# CITY OF ALBUQUERQUE

**Re: Gardner Zemke Addition, 6821 Academy Parkway West NE,  
Request for Permanent C.O. – Not Accepted  
Engineer's Stamp dated: 01-04-12, (E17/D001)  
Certification dated: 08-22-12**

GRADING & DRAINAGE PLAN - SOUTH HALF

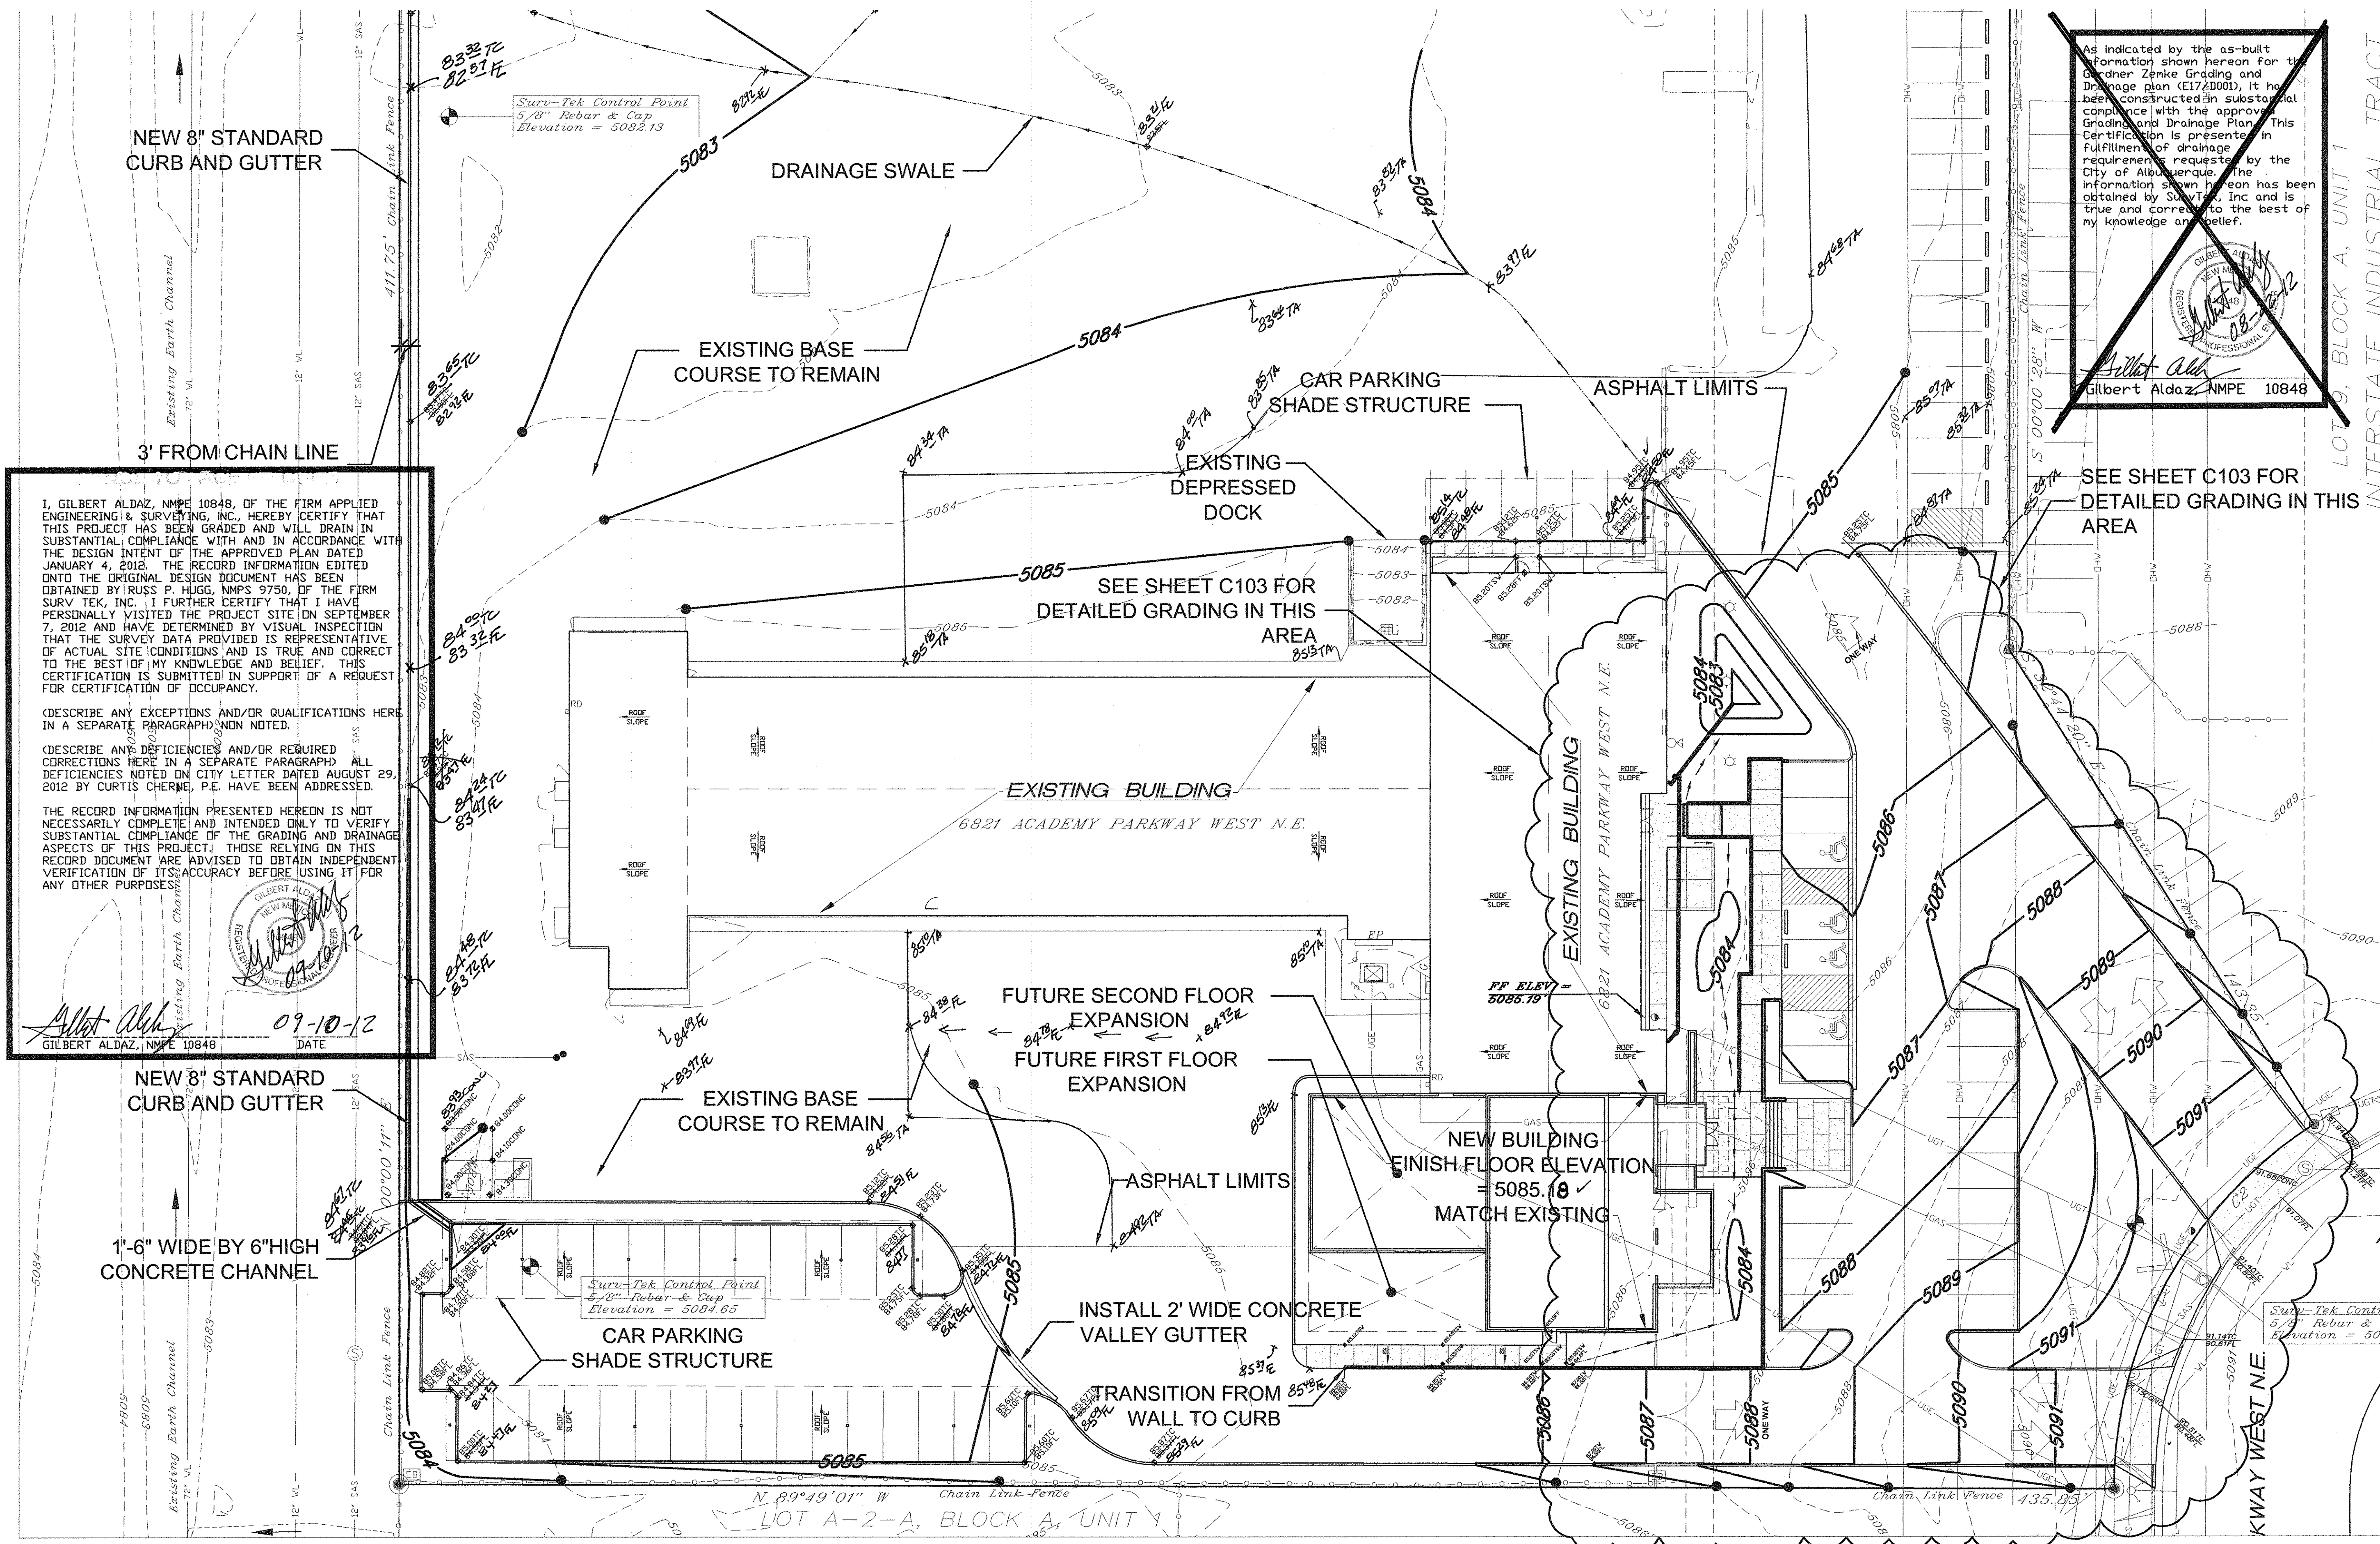
1. It appears a six inch curb was constructed on the western property line in lieu of an eight inch curb. Please provide calculations demonstrating a six inch curb prevents flows from leaving the site.
2. Please certify the pond volume.
3. The Engineer's certifying language will need to be per the DPM, see enclosed.
